8 October 2019

**RE: Amity College New School Campus, Leppington (SSD-9227)**

**PROPERTY: 85 Byron Road, Leppington  
63 Ingleburn Road, Leppington  
Lots: 1 and 2, DP: 525996**

DRAWING TITLE				
PRIMARY DROP-OFF (21-MSC01) LONGITUDINAL & TYPICAL SECTION				
PROJECT NO.	PLANSET NO.	RELEASE NO.	DRAWING NO.	REVISION
P1806493	PS01	R09	PS01-D202	B

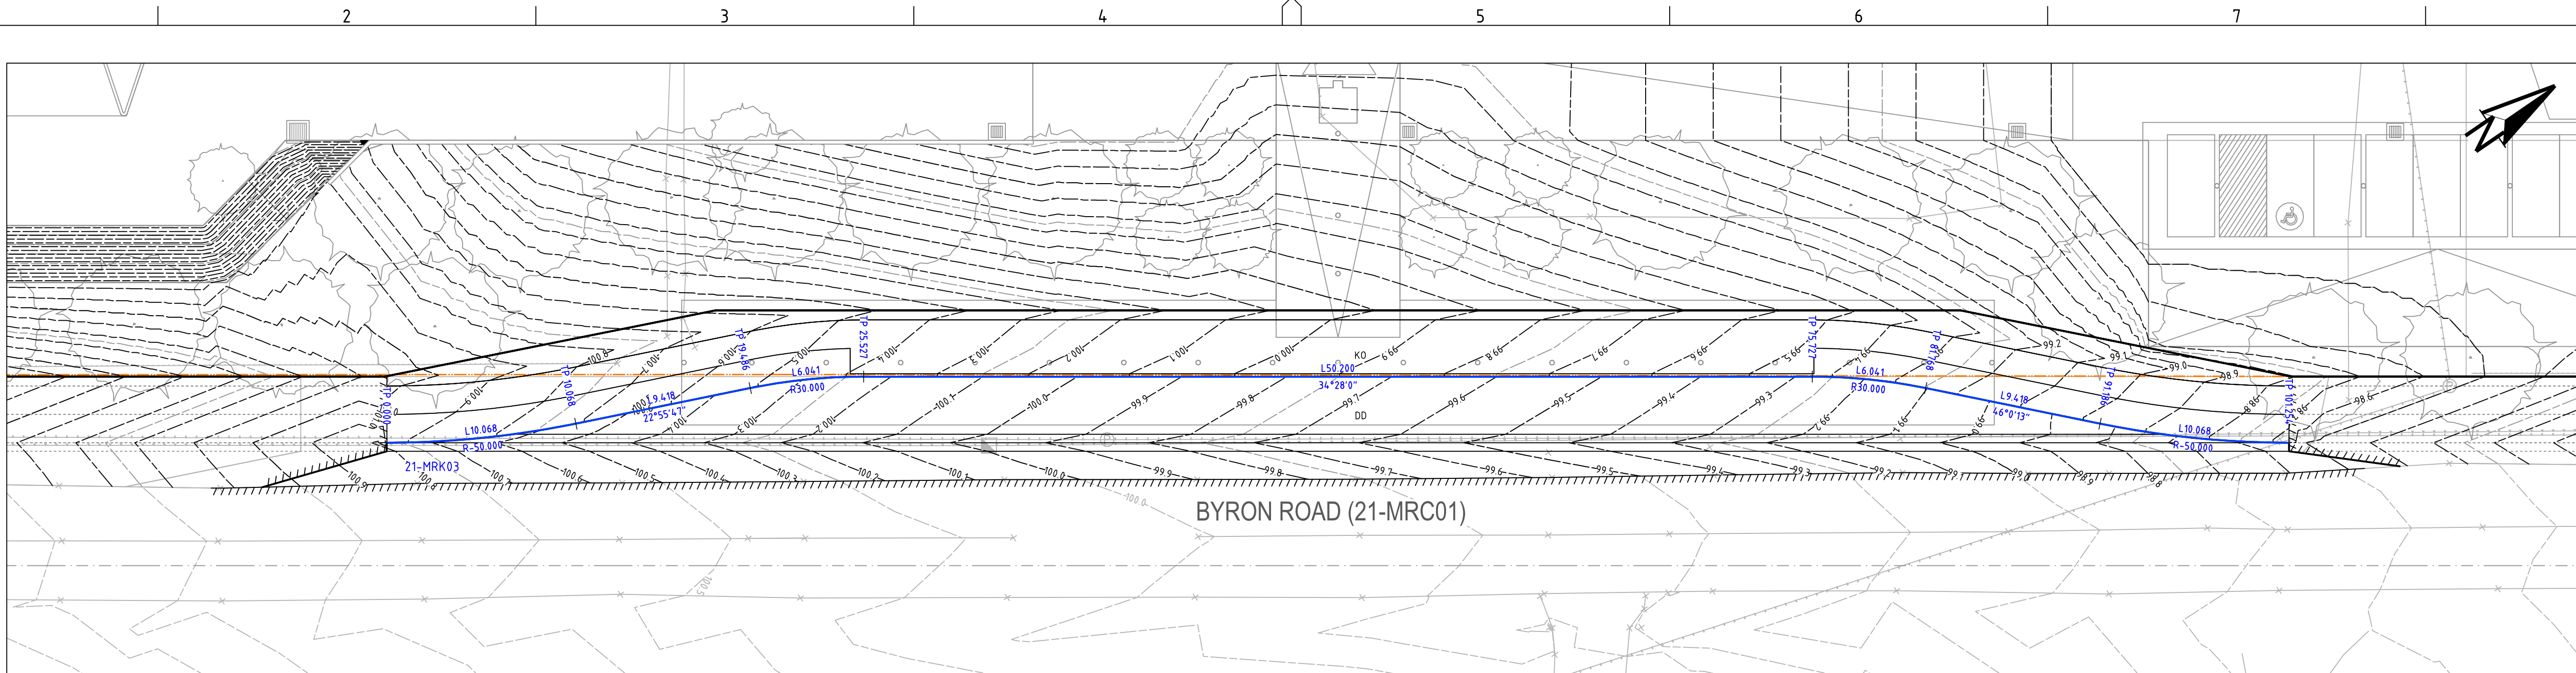
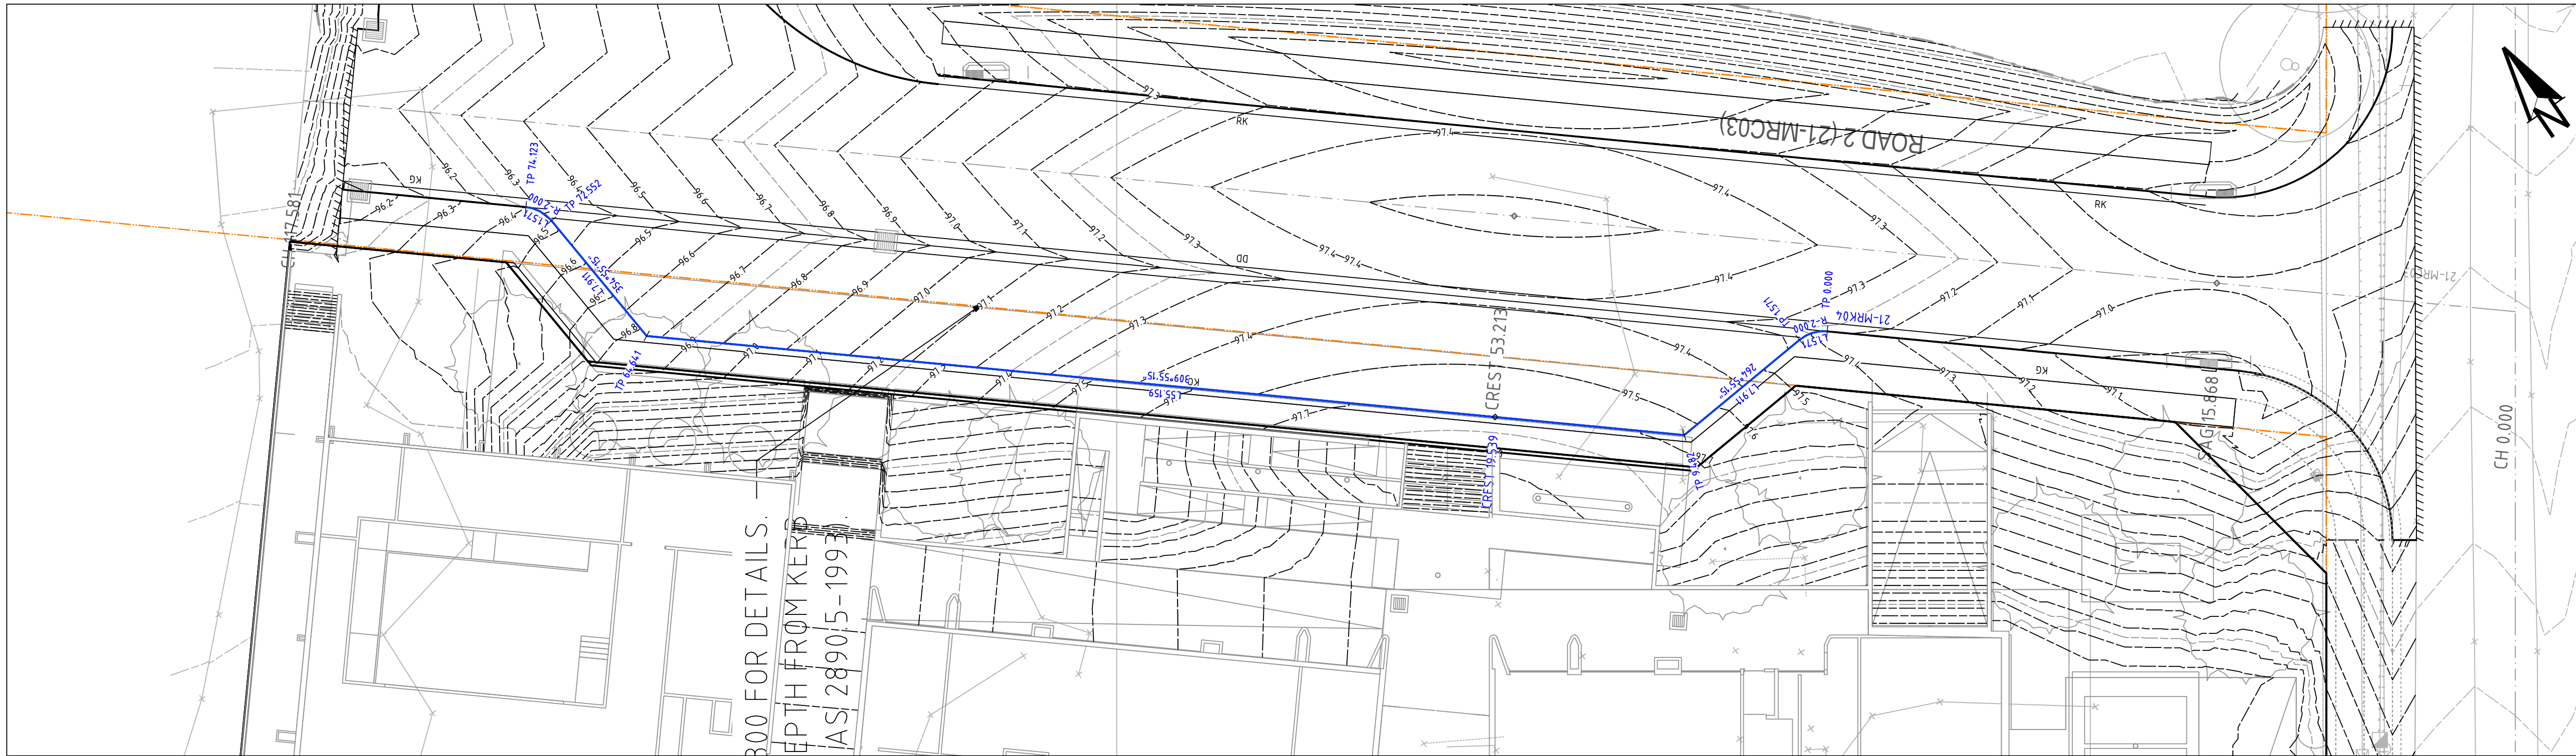
18. The half road construction of road 1 must provide the crown at the middle of the road carriageway. Appropriate keying into the existing pavement is required (300mm bridging at each layer (3 layers)). The new pavement width must be approximately 4.5m instead of the 3.5m shown on civil plan no. PS01-D201 revision E.

DRAWING ID: P18064.93-PS01-R09-E200

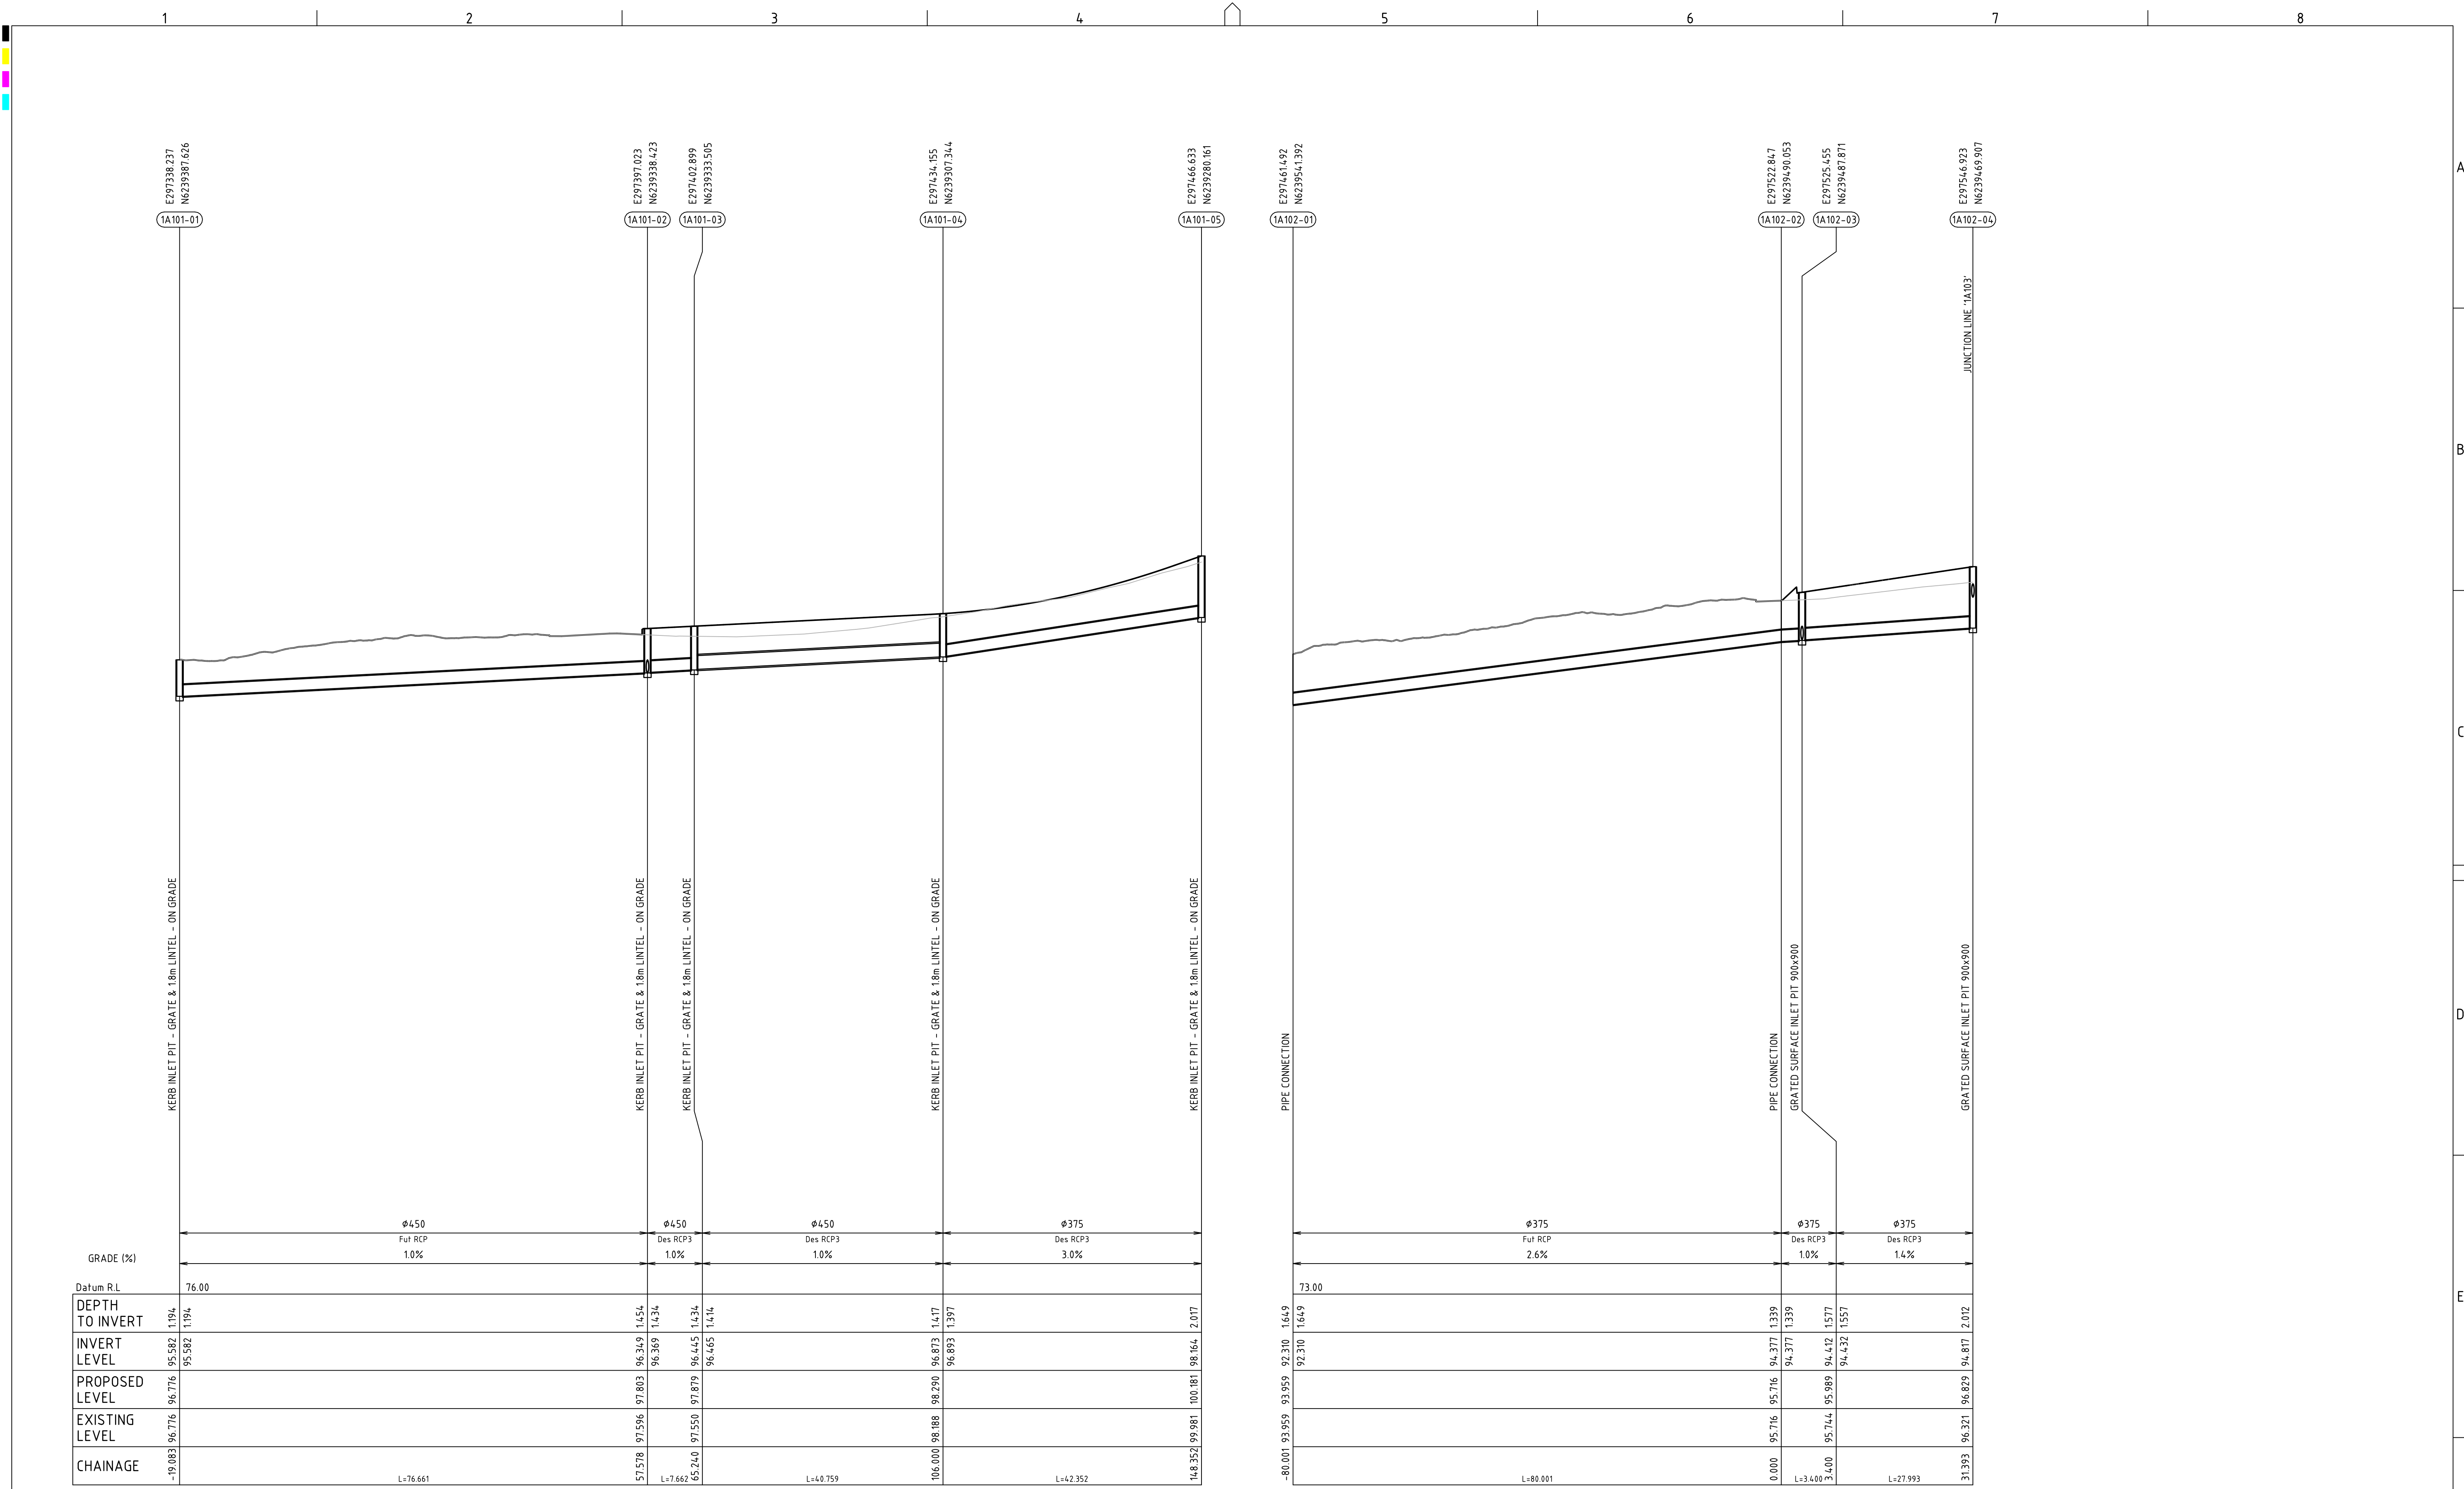
27. Drainage line 1A701 (stage 1) must be clarified (refer to drainage longitudinal section drawing no. PS01-E310 revision A).
28. A MUSIC model must utilise Council's Music Link parameters when modelling the water quality aspect of the stormwater management system.
